# THE VICTORIAN SOCIETY

Your reference: 2023/65/90112/E  
& 2023/62/90024/W

21<sup>st</sup> February 2023

**RE: Listed Building Consent for partial demolition of Listed Building to facilitate refurbishment and extension of the George Hotel to form 90+ room C1 hotel with associated ancillary uses (including bar, restaurant, gym, conference room) (within a Conservation Area)**

Level 03 GEA
1 : 200

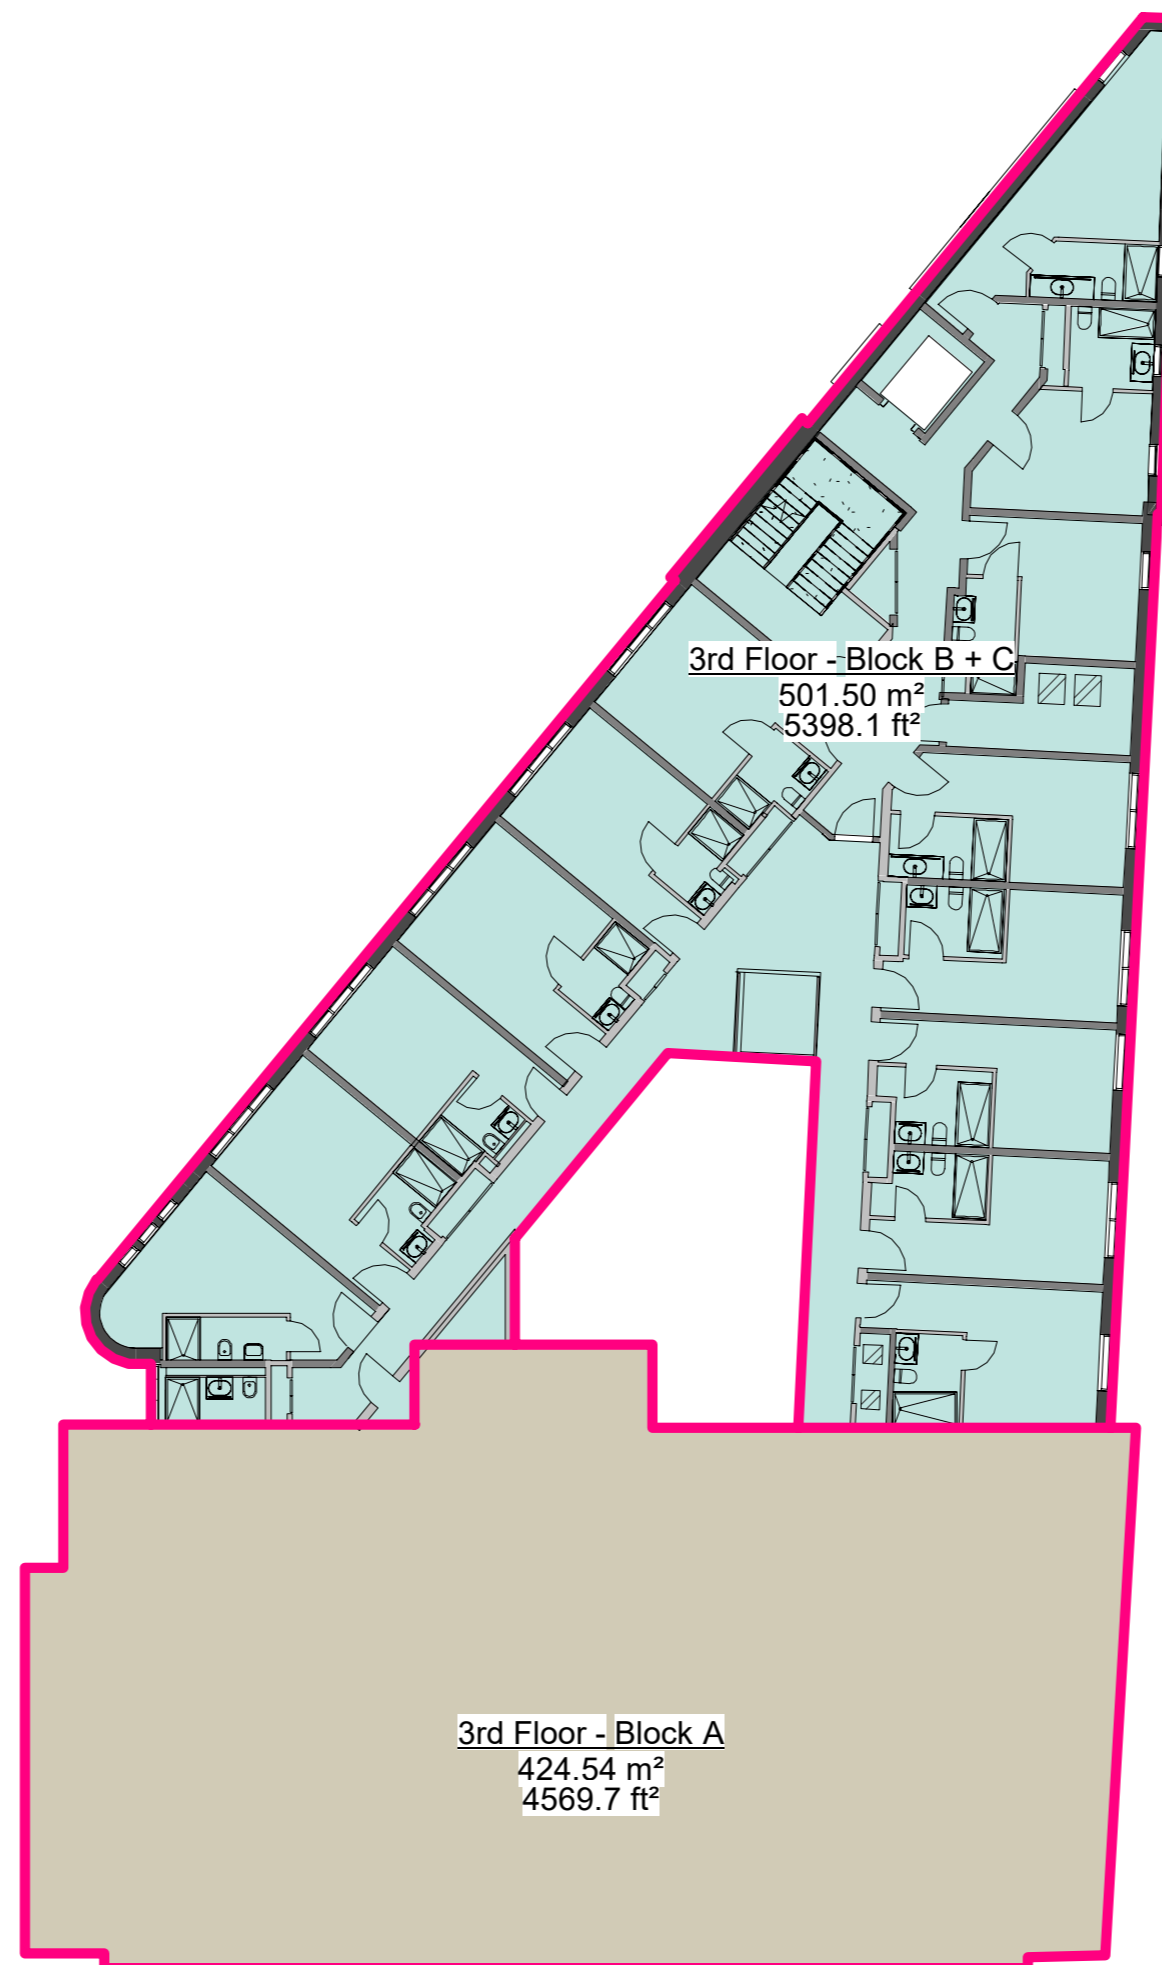
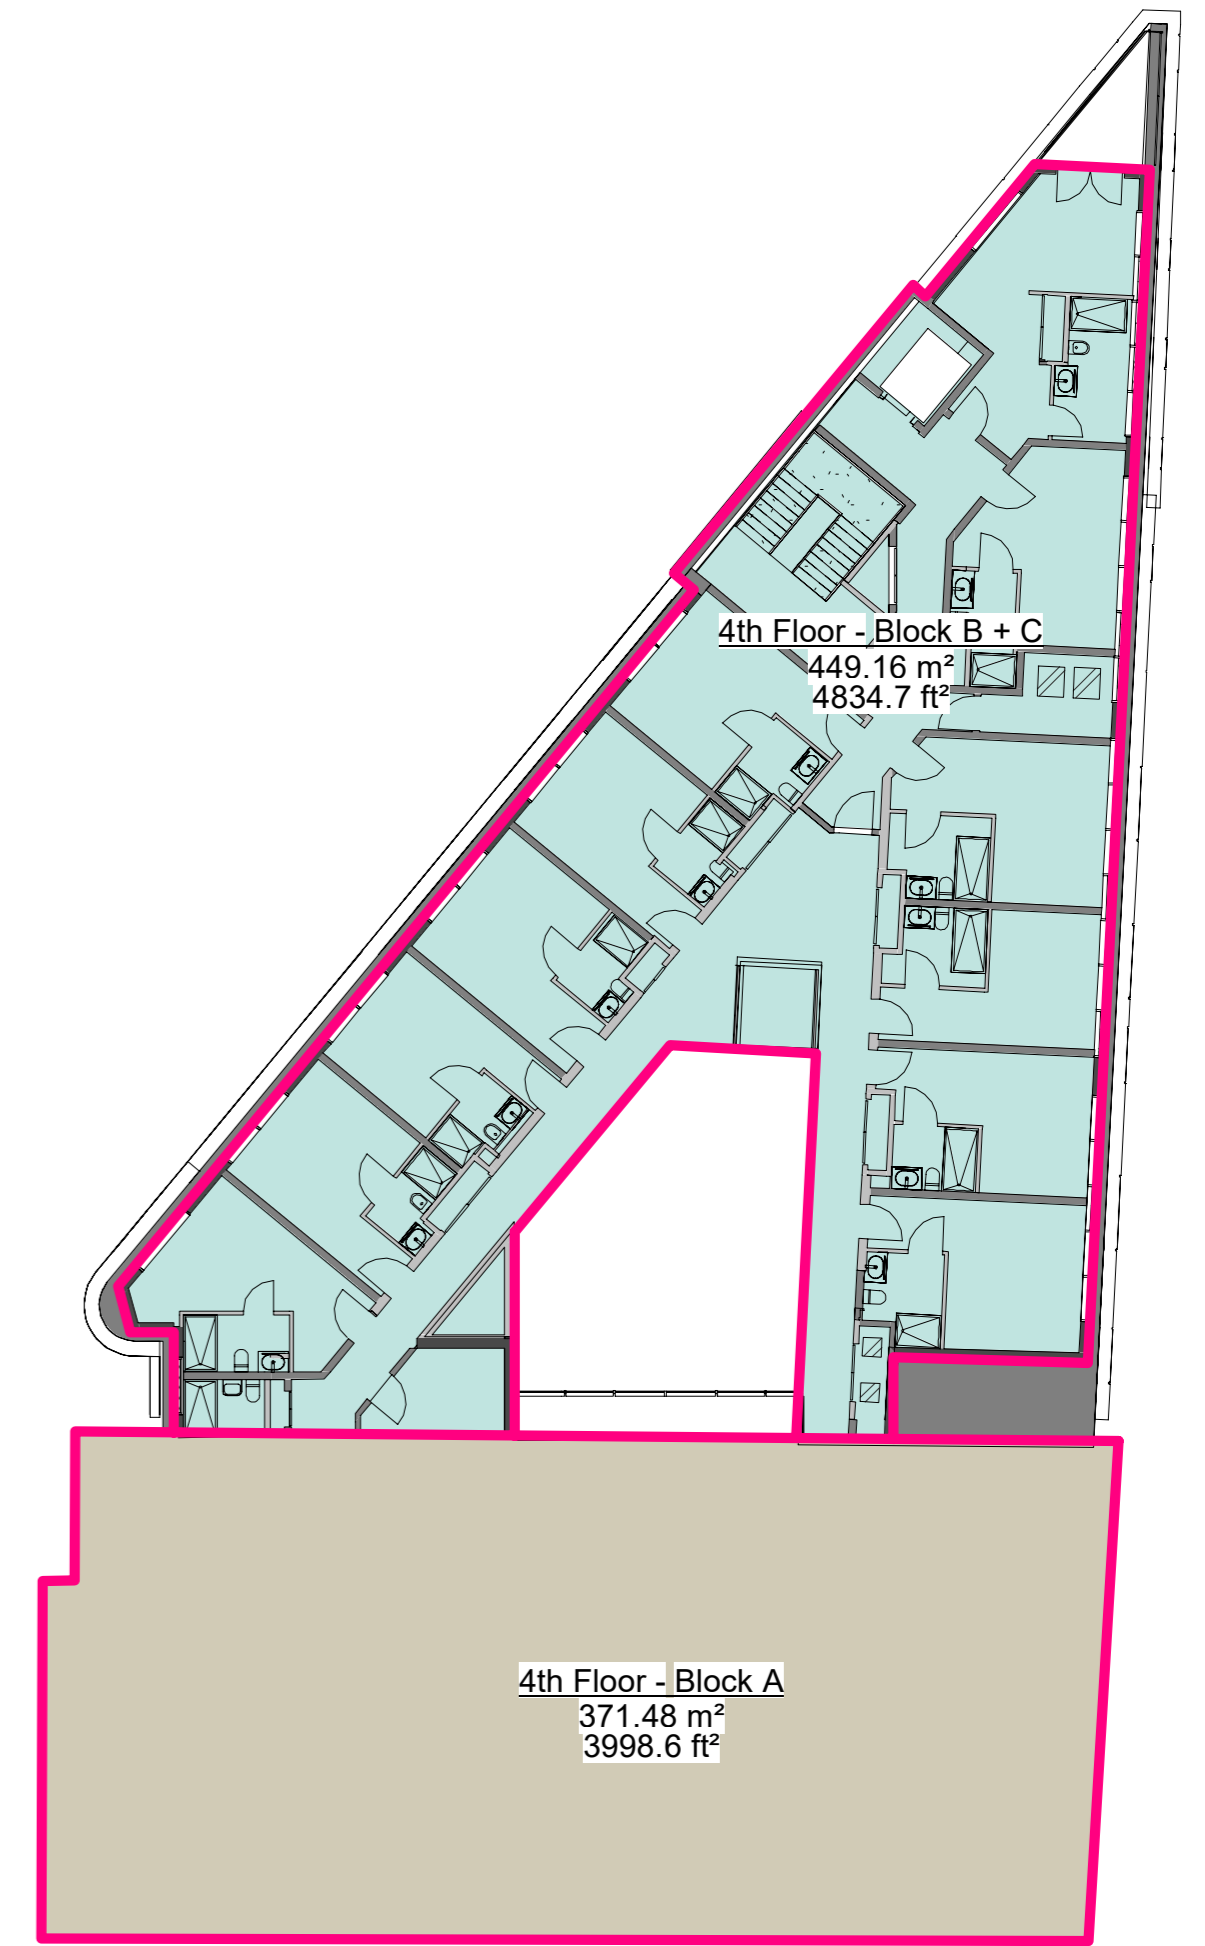
Thank you for consulting the Victorian Society about this application. We **object** to the proposed demolition of the North West wing, partial demolition of the East wing and additional 3 storey extension.

The proposed massing of the extension which would replace the NW wing and most of the E wing is too large. It would overwhelm the careful classical proportions of the principal block and the surviving façade on John Williams Street. The immediate conservation area is characterised by classically proportioned buildings, a hallmark of classical architecture, with the exception of pediments or domes, is a flat roof. Buildings from this period in the design are often built with discrete mansard dormers that disappear or are non-intrusive at street level.

The massing of the proposal would be visually jarring and greatly distract from the carefully executed classical design of the hotel and neighbouring heritage assets. Furthermore, given the grade II\* status of this building and the group value of this area, it is surprising that the design of this extension is so poor and low quality. The massing and design of the proposed extension would cause substantial harm to this heritage asset and less than substantial harm to the Huddersfield Town Centre Conservation area.
